Consultation Response from KC, Highways Development Management
2026/92271 Joseph Norton Academy Former Deighton Centre, Deighton Road, Huddersfield, HD2 1JP
Advertisement Consent for erection of non illuminated signs
Date Responded: 28/09/2026 Responding Officer: CNB Responding Ref: K4-8NE/2

This application is for advertisement consent for the erection of several non-illuminated signs at a new school.

1-E-011

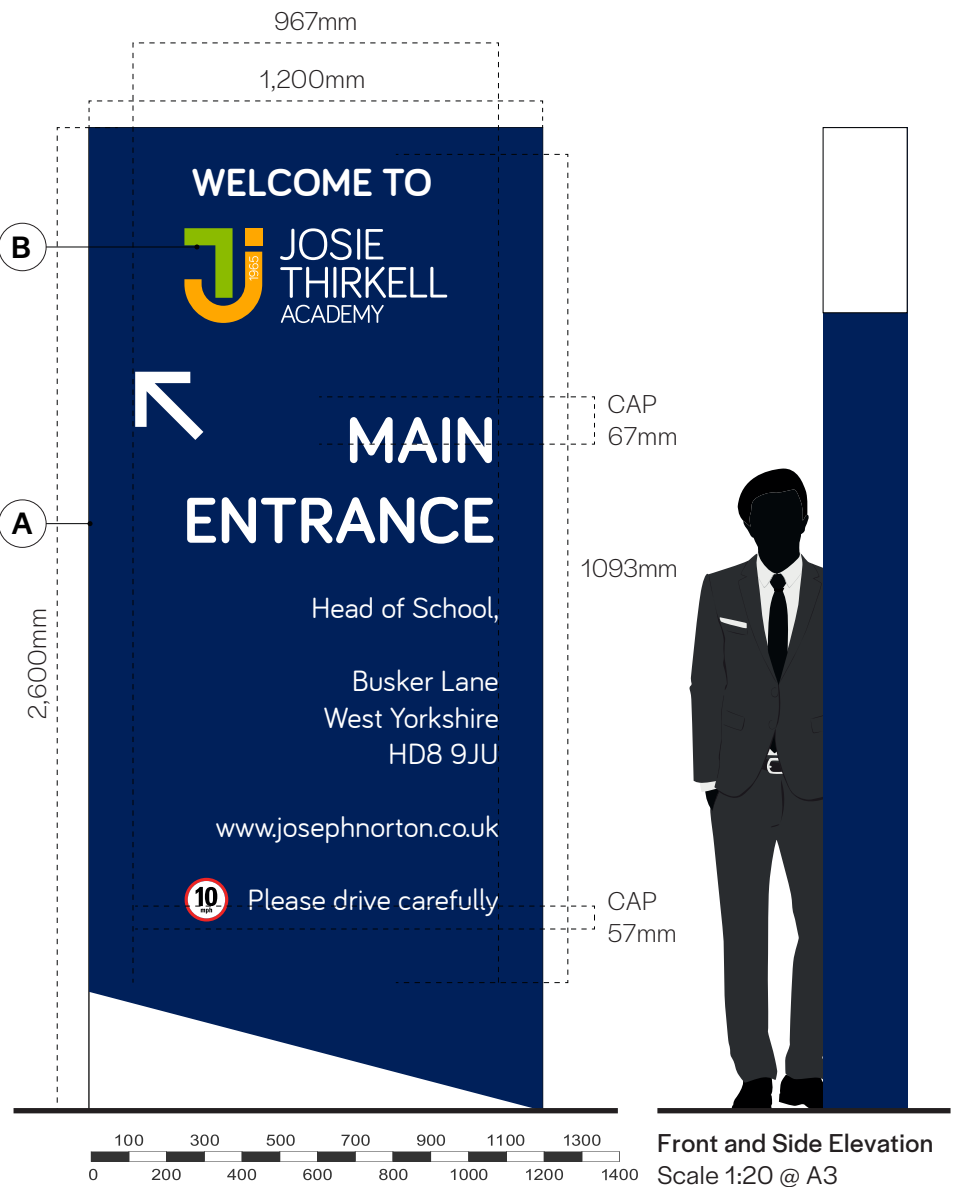
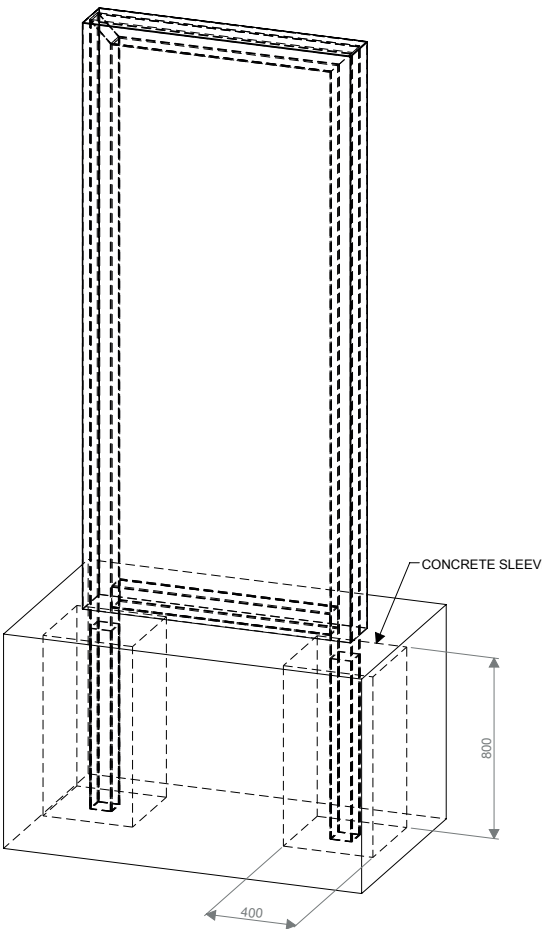
The only sign that is located adjacent to the highway is marked as 1-E-011 on the drawing and is located at the entrance to the site. This is a 2.8m high totem indicating the name of the school, direction of the main entrance and other contact information. It is noted that a similar non-illuminated sign was located to the rear of the grass verge for the previous use of the site, however the proposed sign appears to be located further forward than this and may be within the adopted highway, and as such would require the appropriate legal agreement with the Local Highway Authority before it could be erected. This information should be added as a footnote.

Based on the drawing (which is unscaled and therefore couldn't be measured), the location of the sign appears to be approximately 2.3m behind the kerb line of B6107 Deighton Road, and as such may be within or interfere with the safe visibility splays for the exit from the site, and this would be a highway safety concern.

It is also noted that the sign would likely obstruct pedestrian movement along the footway, especially as it appears to be placed on the desire line between the existing footway along Deighton Road and the dropped kerb crossing across the access to the site. This would also be a highway safety concern.

Due to these dual highway safety concerns we cannot support the application as submitted.

We would like to see the sign No 1-E-011 moved to either the rear of the footway or on to the grass verge. This would place it behind the visibility splay and would not obstruct the footway. This relocation may still require the correct legal permissions from the Local Highway Authority.
